STATE OF NORTH CAROLINA
DEPARTMENT OF TRANSPORTATION

Addendum No. 1

Dare County (F-5700)

Construct 183'-7" X 46' X 10'-6" Passenger/Vehicle Ferry

Drawing file: Individual Sheets / 16101-200-110-1A_Bottom_and_Side_Shell.pdf

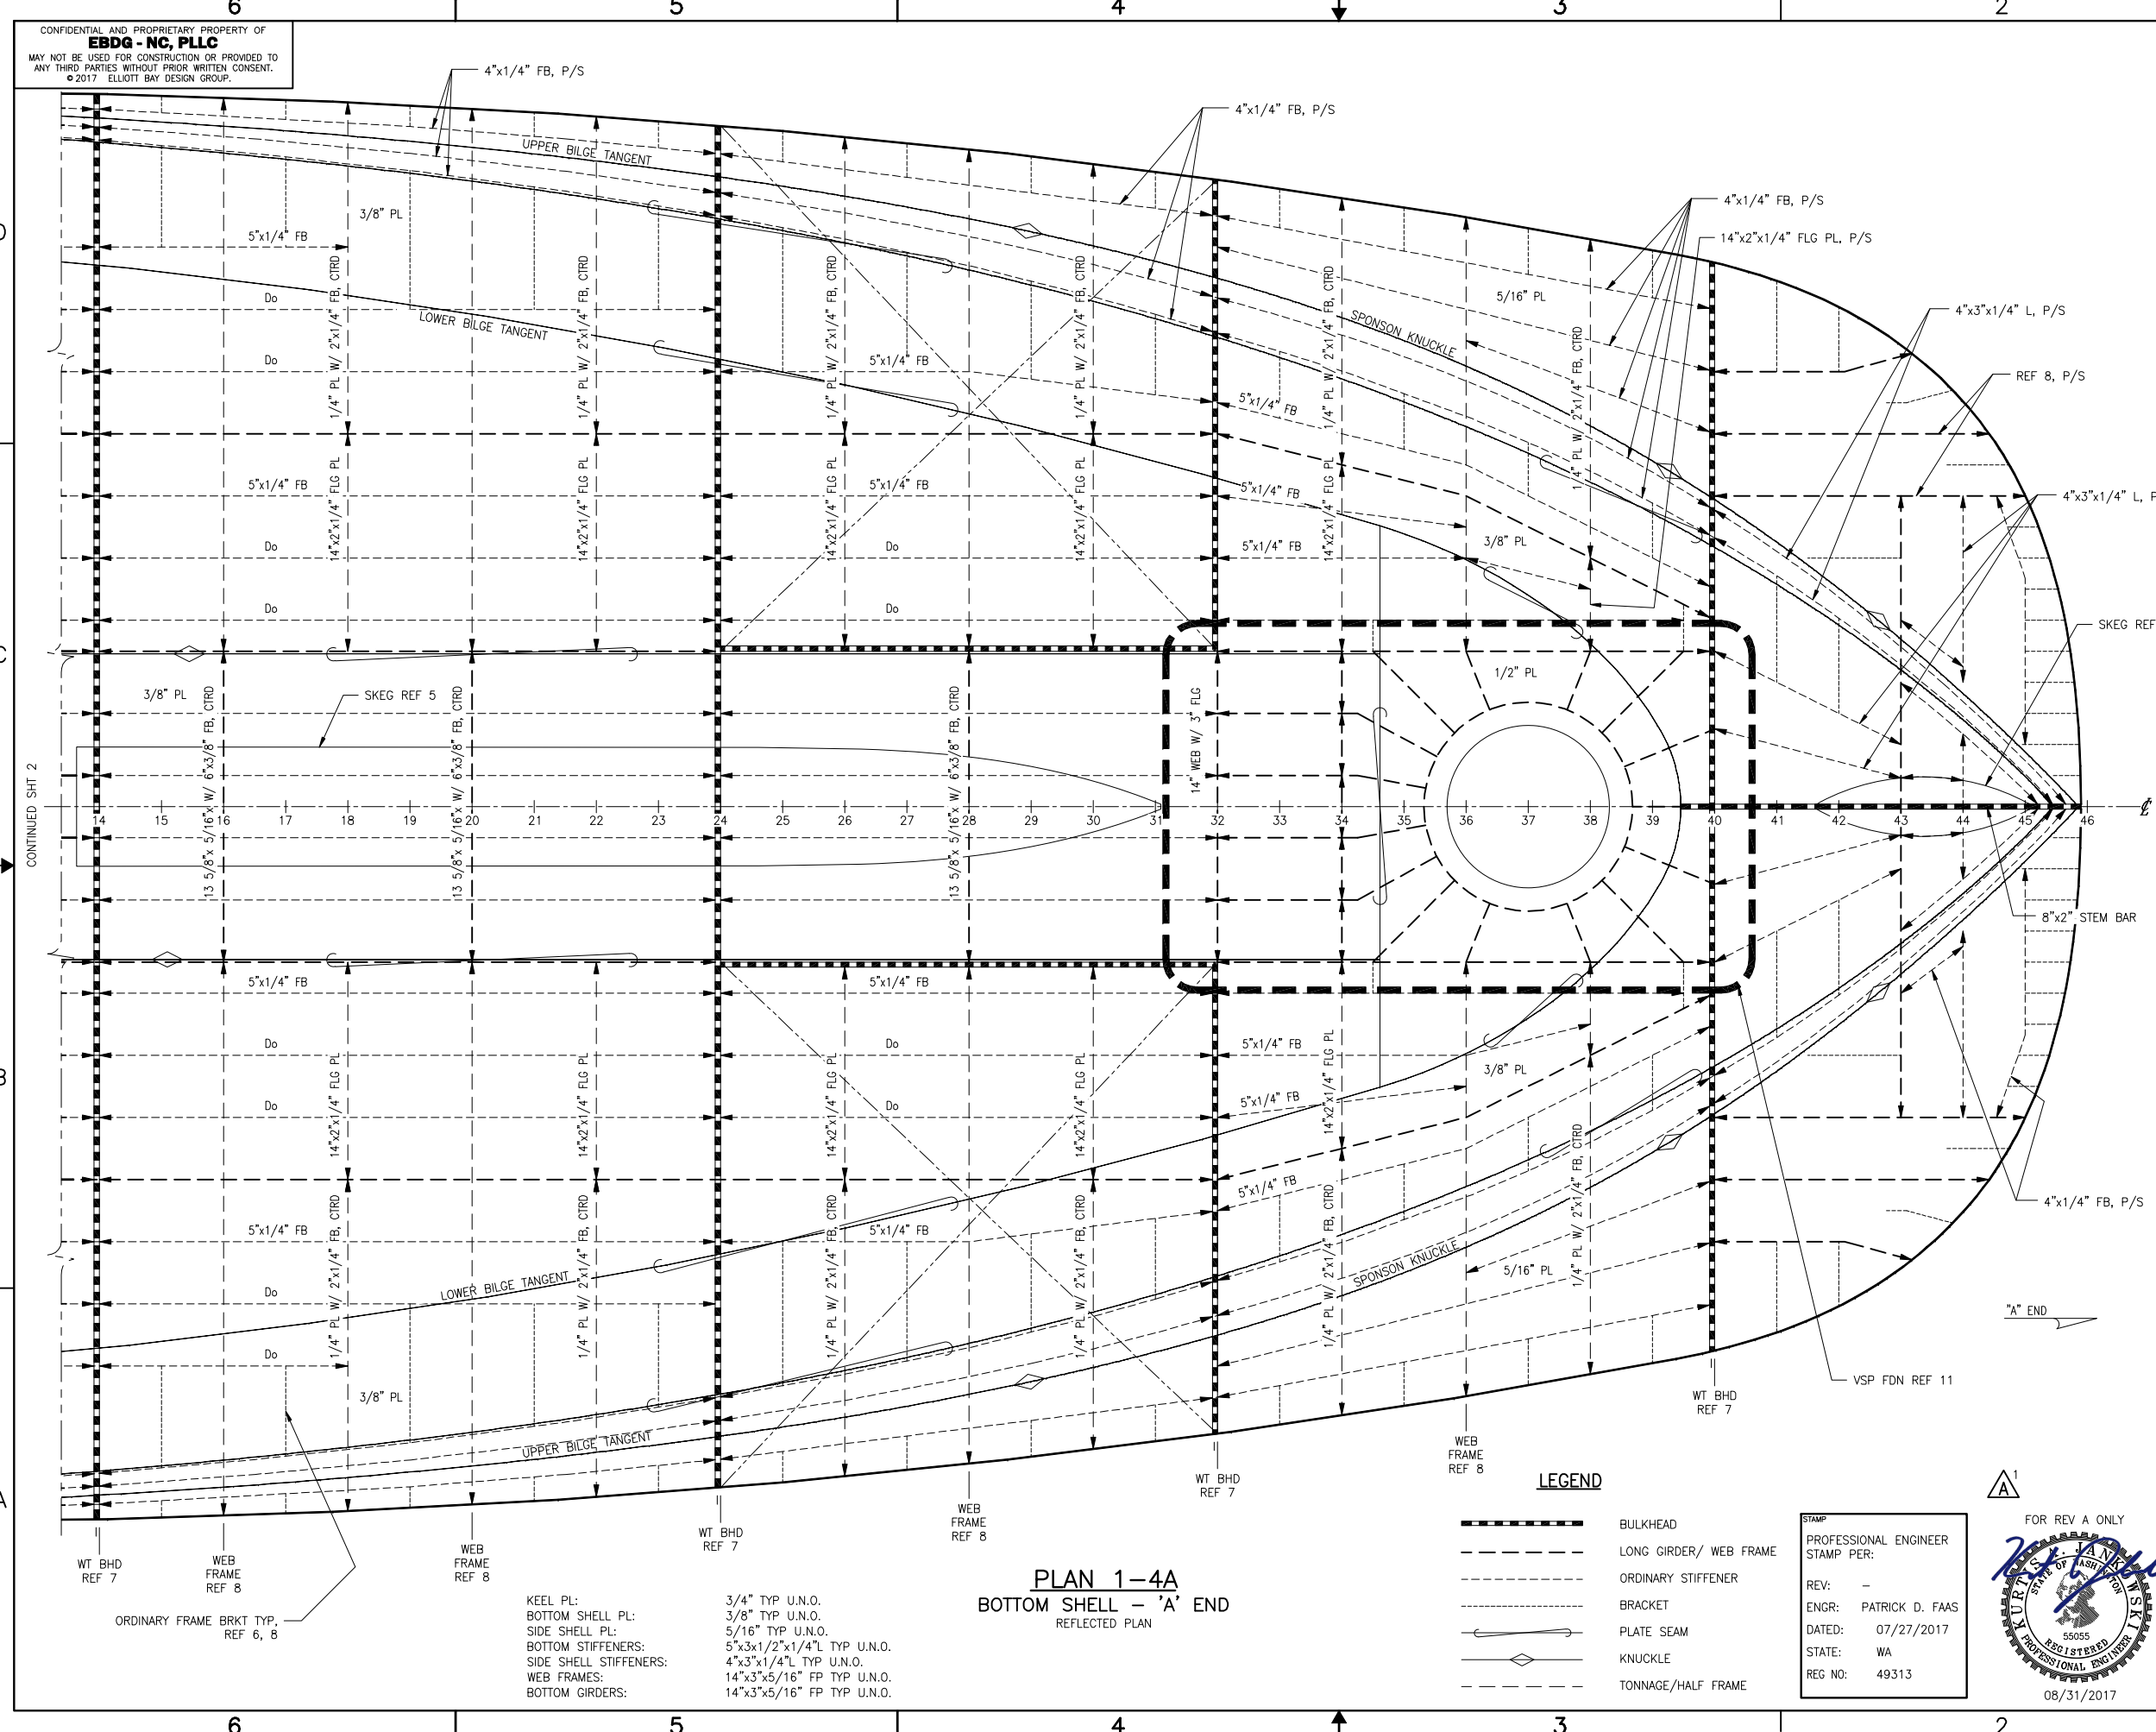
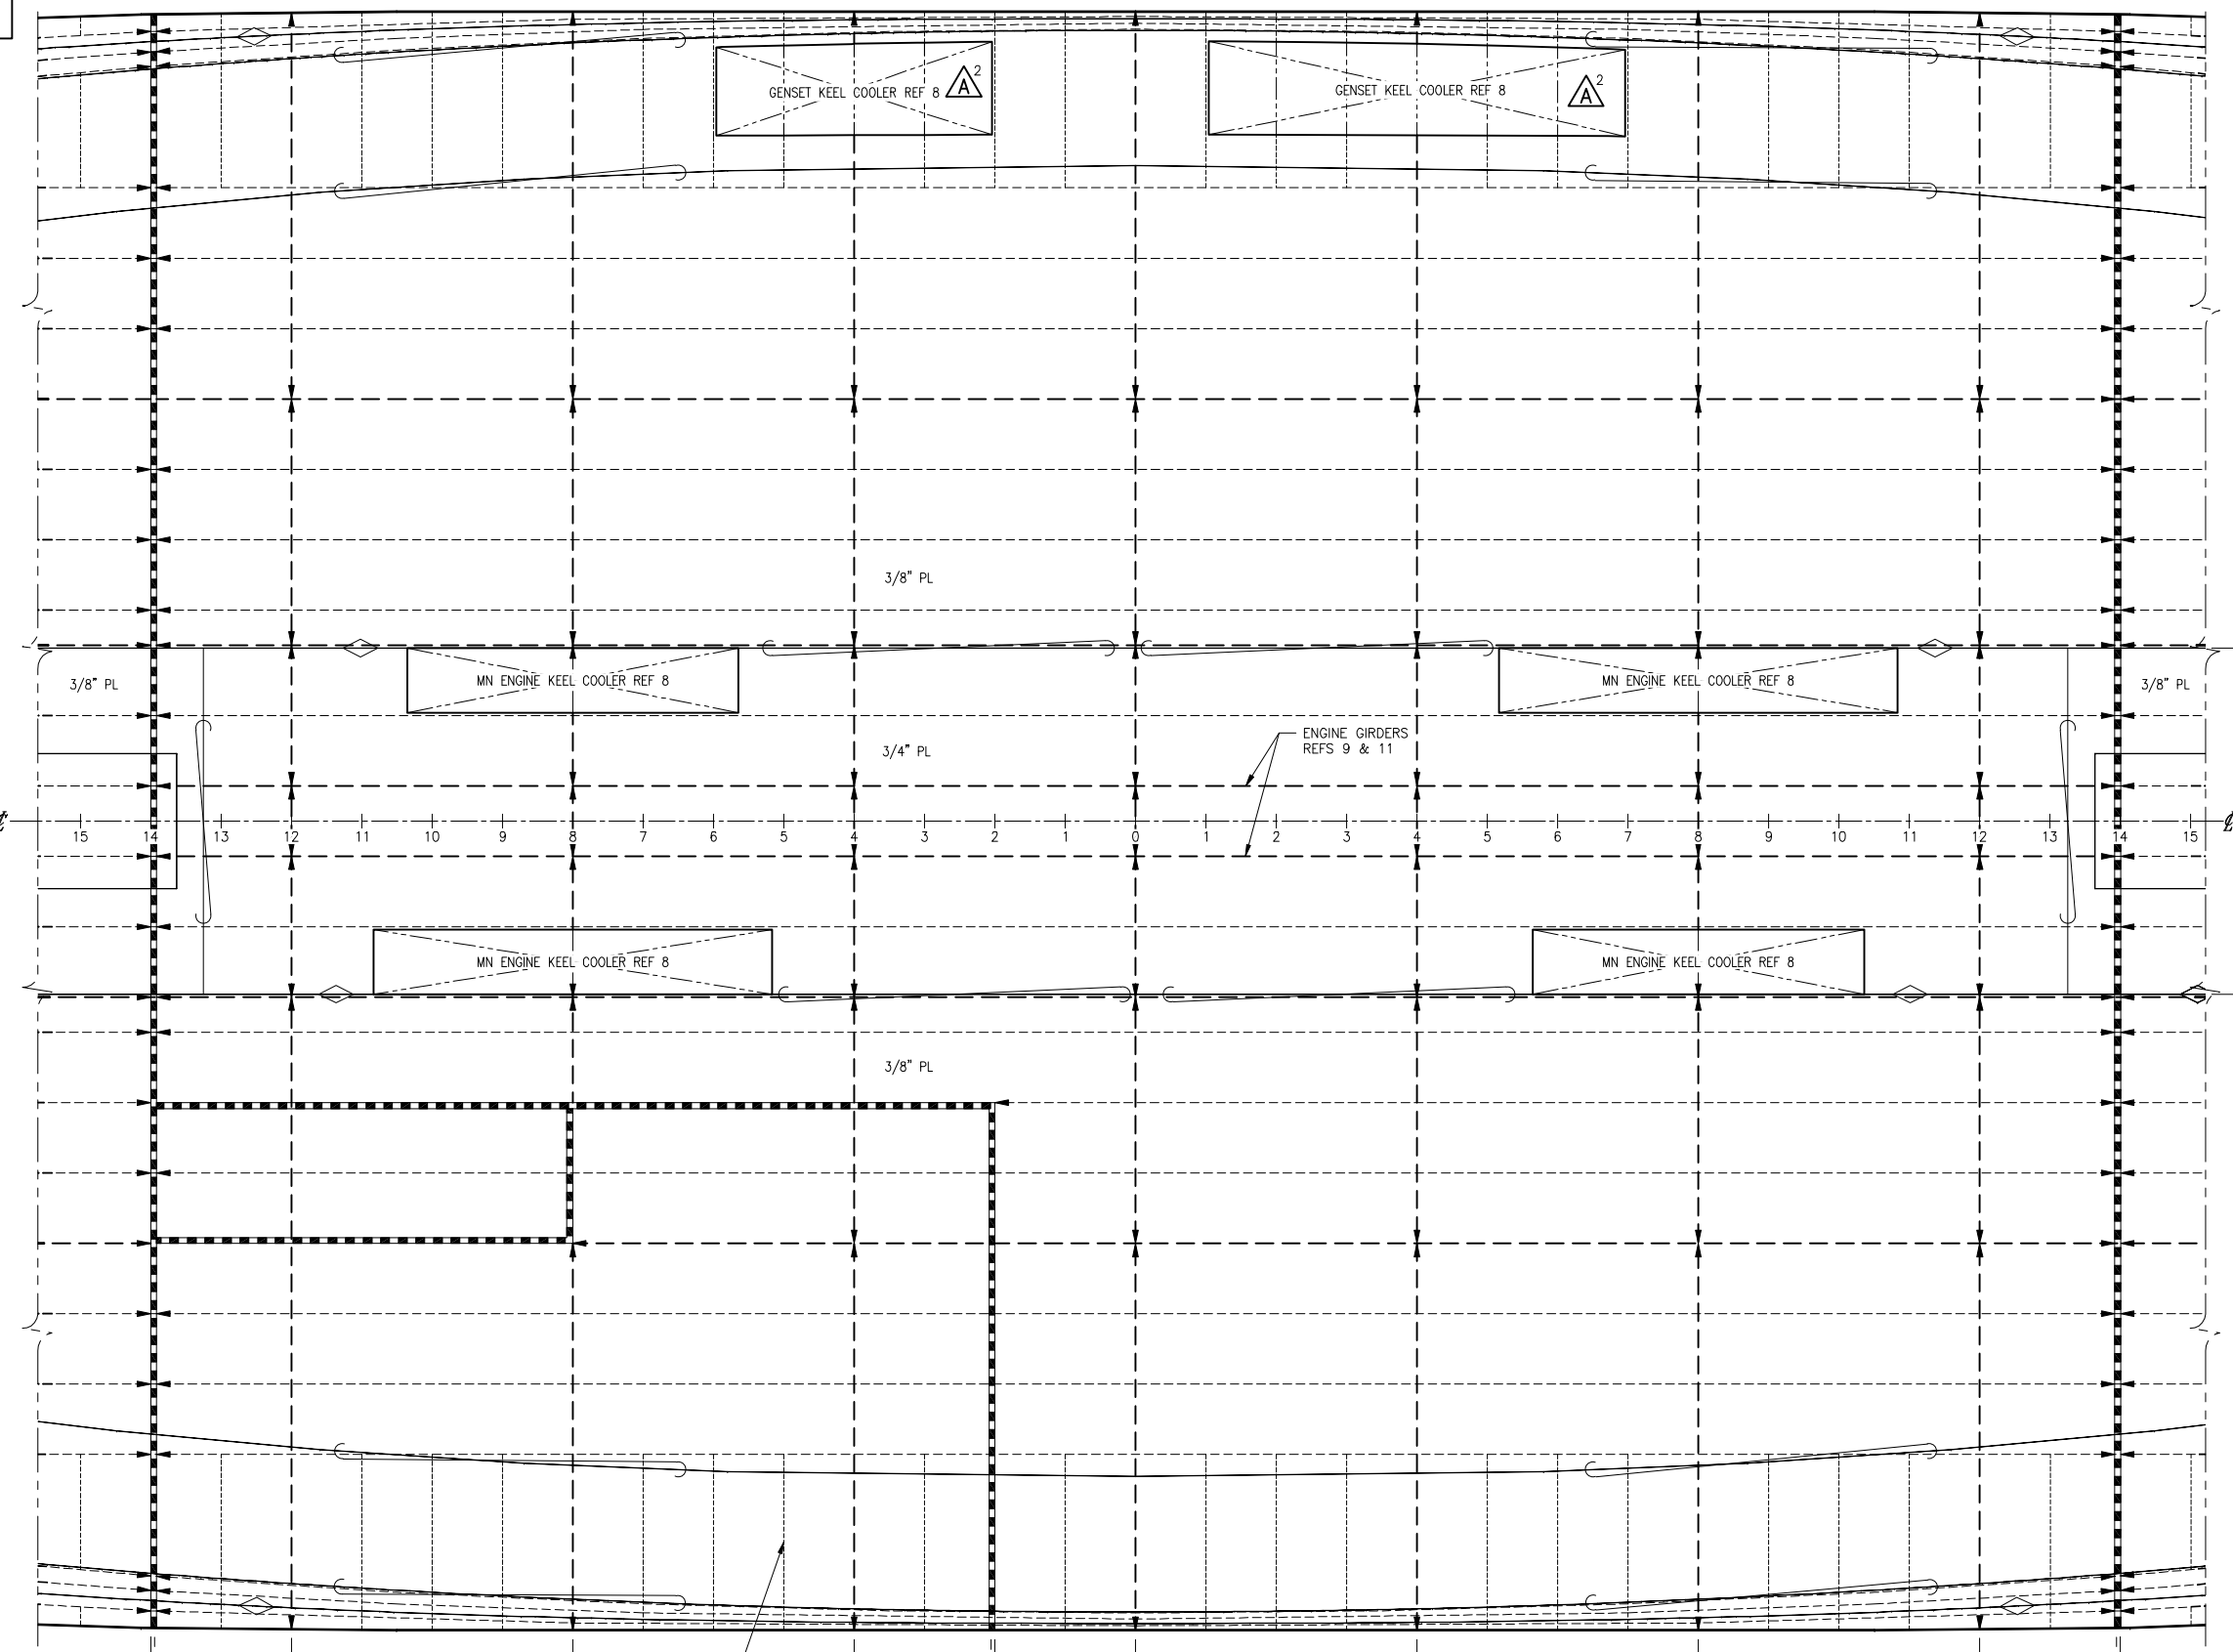
Sheet No.	Revisions
	Lines Plans
100-1: Sheet 1, Zone 2B	Removed 10' and 12' waterlines from body plan
100-1: Sheet 1, Zone 3B	Updated description of bilge tangents
100-1: Sheet 1, Zone 5B	Added transverse chine line to flat hull
100-1: Sheet 2, Zone 2A	Added thruster CL Frame 37 to shear plan
100-1: Sheet 2, Zone 2C	Added transverse chine line to flat hull
	Profiles and Deck Arrangements
101-1: Sheet 1, Zones 3B & 5B	Relocated masts to Frame 23
101-1: Sheet 2, Zone 3C	Added camber and tumblehome dimensions to midship section
101-1: Sheet 3	Updated chock and cleat locations in main deck plan; added hatches to main deck and hold plan views and added tank capacities to hold plan
101-1: Sheet 4, Zone 1D	Added grab-rail to pilot house console detail
101-1: Sheet 4, Zone 2D	Modified pilot chair location / size in pilot house console detail
	Bottom and Side Shell
110-1: Sheet 2, Zone 4D	Reversed position of keel coolers about midship

110-1: Sheet 4, Zone 4B	Reversed position of keel coolers about midship
